DEVELOPMENT REVIEW BOARD

Code Enforcement Comments

PR-2023-008085

ISAACSON & ARFMAN, INC. agent for **LEPPKE INVESTMENTS | LAS VENTANS HOMES** requests the aforementioned action(s) for all or a portion of: **TRACT A-1, SPANISH WALK** zoned **PD** located between **4TH ST** and **CAMINO ESPANOL** containing approximately **2.4401** acre(s). **(E-14)** [Deferred from 11/8/23x]

1 SIGN SCALE: N.T.S.

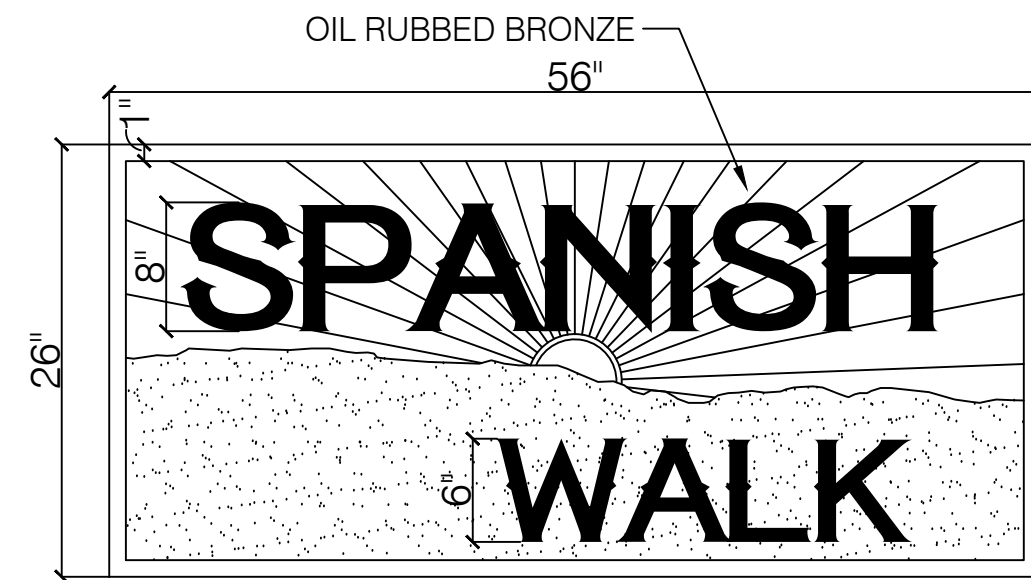
- 3. Proposed sign would not be allowed in a residential district, as per Table 5-12-1, which is referred to in IDO 5-12(F)(1), below. Again, if EPC Site Development Plan submitted, it is possible to pursue signage.*
